# Pagham Beach (Holdings) Ltd

re. Property: 113 West Front Road, Pagham PO21 4TB

Application: ADC Ref: P/117/24/HH

Proposal: Raising of the roof and roof re-design with a side gable and a side dormer.  
First floor rear balcony

Proposed Elevation-Right side

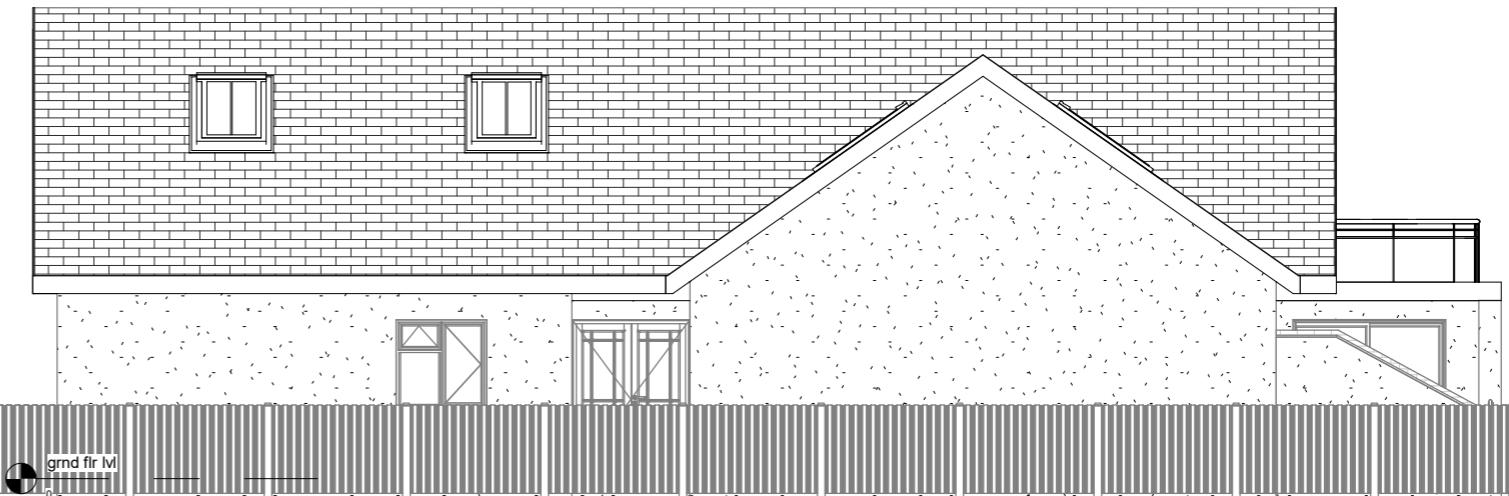
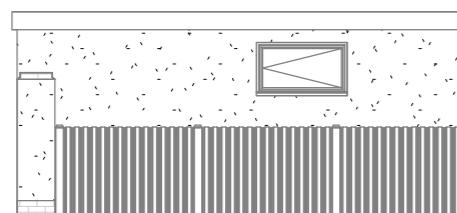
- The proposal seeks to create a gable with side window on the east side of the building, which is an un-neighbourly proposal and will create overlooking to the adjoining property to the east. For this reason therefore, the Application should be Refused.

P.S. I would point out that the Applicant's agent has incorrectly attributed east and west to a number of elevational Drawings, which are therefore misleading and I am surprised that the District Council's Scrutiny Officer has allowed these Drawings to be registered. The Drawings submitted should be reviewed and corrected.
